Subject: 31 Albert Road, Rustington - R/156/20/PL

We live at 23 Mill Lane and have noted the response to various objections, by the agent for the above mentioned proposed development. We wish to add further comments in relation to those noted by the agent, to further support our objection to this application.

DRAWING TITLE
PROPOSED ELEVATIONS

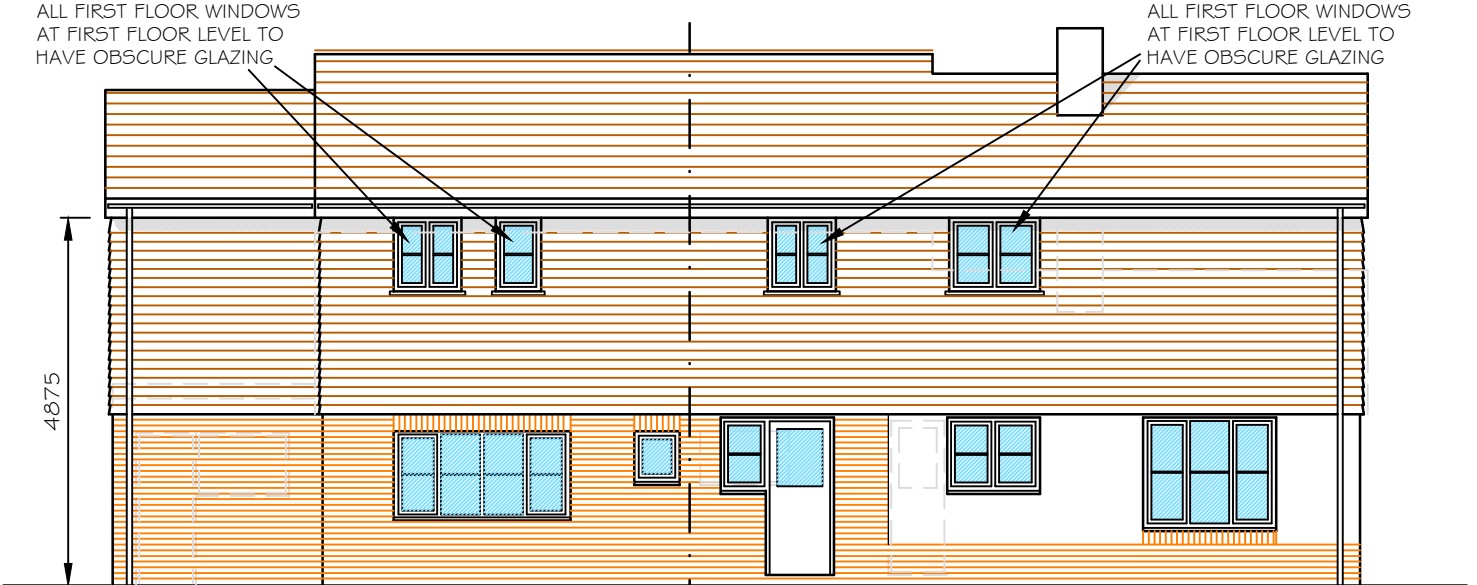
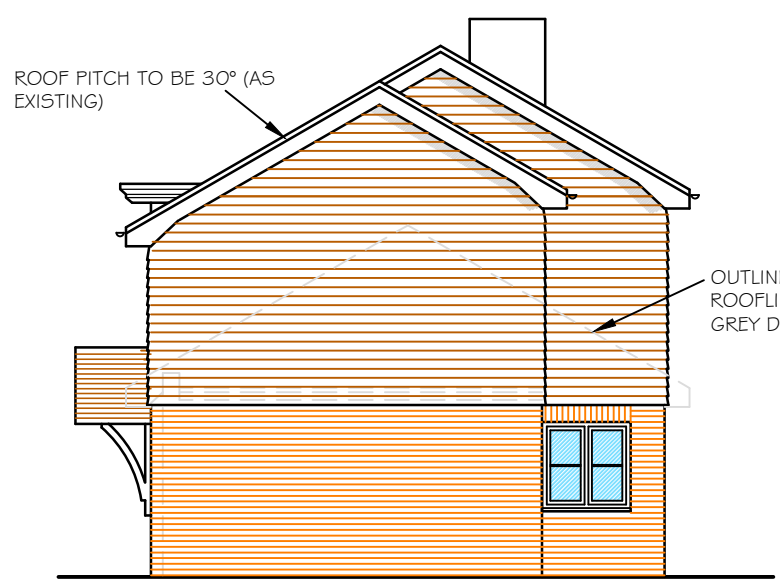
Overlooking – whilst a condition may be added that the windows along the rear elevation at first floor level should be non-openable, this is a notoriously difficult to monitor non-opening window conditions, as raised by our representative Phil Rowe in his objection to the application.

Furthermore, there is no datum level information submitted by the agent to support the application for the proposed development, so therefore no evidence to justify their claim that the ridge height of the new houses would not exceed that of the existing properties along Mill Lane. In particular, that the ridge height of the new development would not exceed that of 23 Mill Lane, which is in very close proximity.

DRAWING TITLE
SITE LOCATION AND BLOCK PLANS

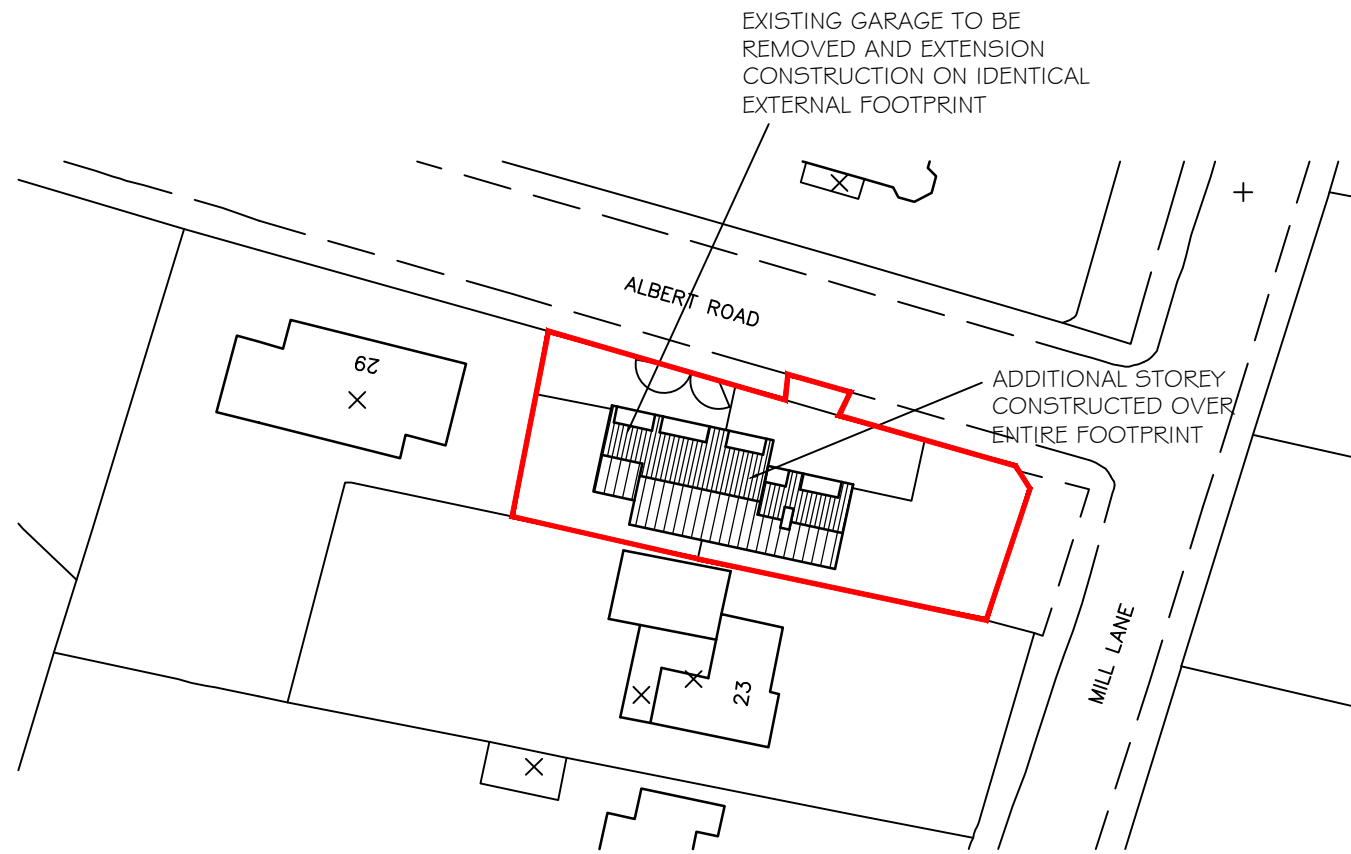
Lack of external amenity space – the agent attempts to counter objections to the lack of external amenity space for the proposed development, by precedent set of approval of a development on 1 Woodlands Avenue. The properties in the immediate vicinity of the proposed development are a mix of 1920s detached houses with generous amenity space, circa 1960s semi detached houses, also with good sized amenity spaces and immediately adjacent to 31 Albert Road, circa 1960's bungalows with external amenity space which far exceeds those proposed for the new development. There are no properties in the immediate vicinity which, to the best of our knowledge, have external amenity spaces as small as those proposed in this application.
